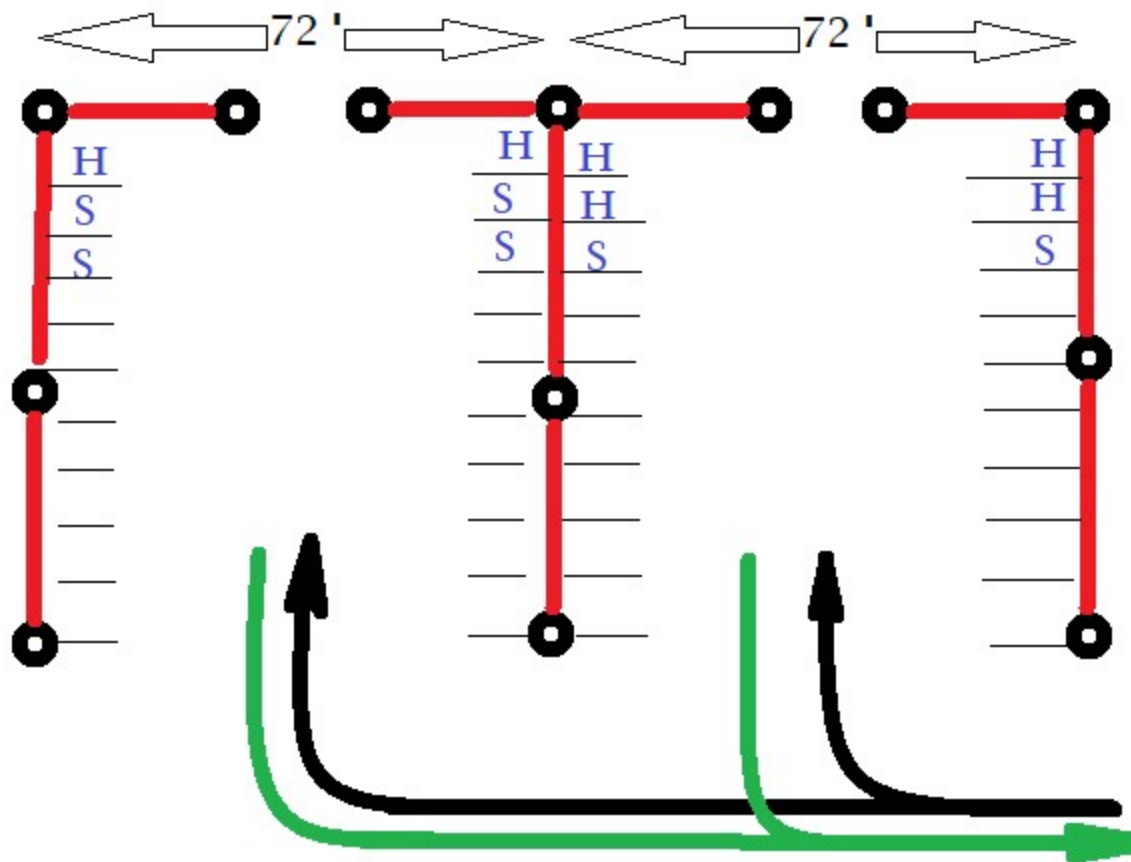
Include how many trees you are proposing, include trees and landscaping features that are existing on the property.
